**ADC Planning Consultation
Conservation/Design Officer Response**

Application Number	LU/164/17/HH
Address	Exeter House Flat C, 1 Fitzalan Road, Littlehampton
Description	Alteration to the fenestration of a building in an Area of Special Character
Case Officer	Anita Gardner
Date	23 August 2017

REPLACE EXISTING WINDOW WITH DOOR 1st FITZALAN RD - BN17 5JL SCALE 1:50
REF: PP-06074503 LU/164/17/HH DRAWINGS BY MRS C WALLIS SHEET 1 OF 2

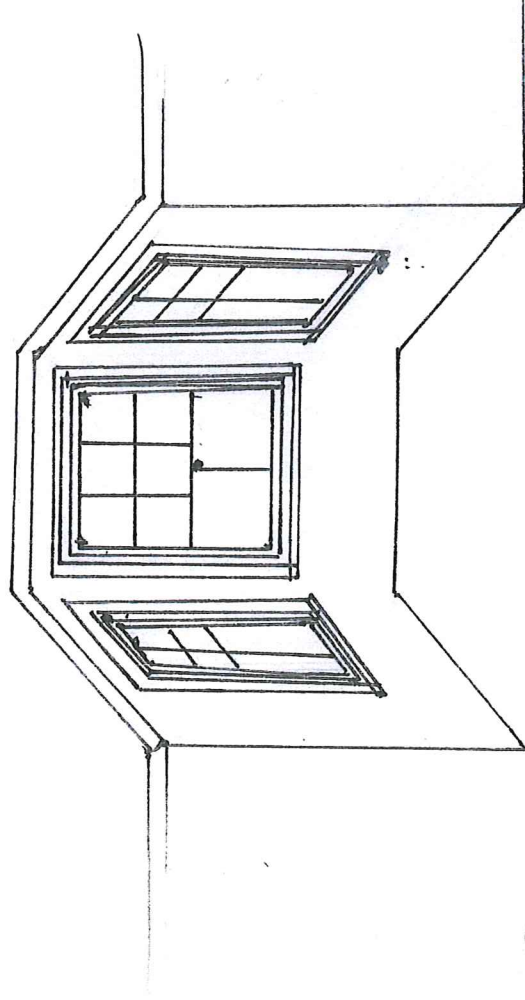
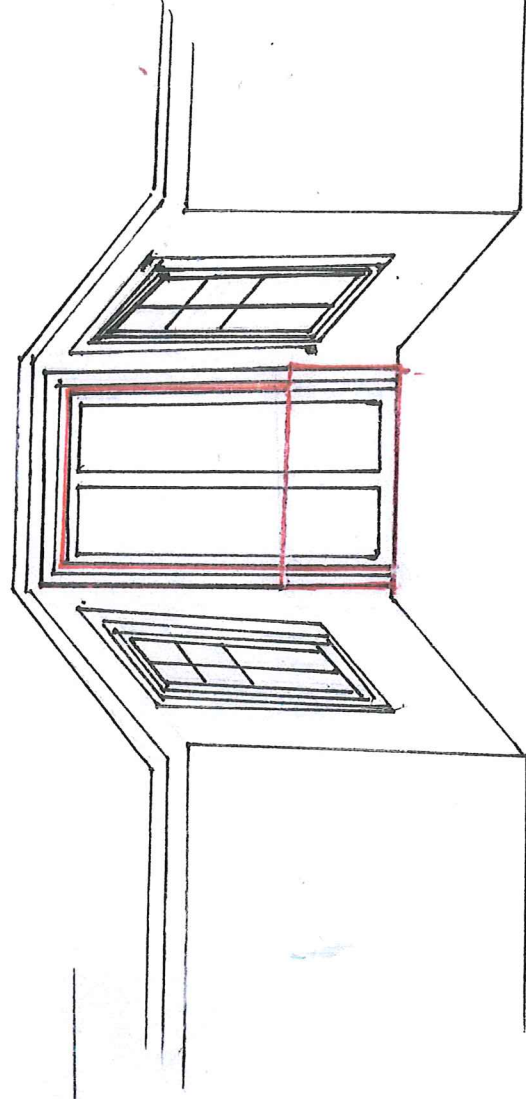
Within a designated area, the use of UPVC is strongly resisted, as it is a modern 'anywhere' material, devoid of local character and inappropriate to the context. In order to preserve the general appearance of the host building - and maintain its contribution to the special qualities of the designated area - the new door frames should be of timber so that they complement adjacent, original windows.

Poor precedents elsewhere do not justify further use of unsympathetic materials, as the cumulative effects erode the locally distinctive qualities of a designated area and harm its significance.
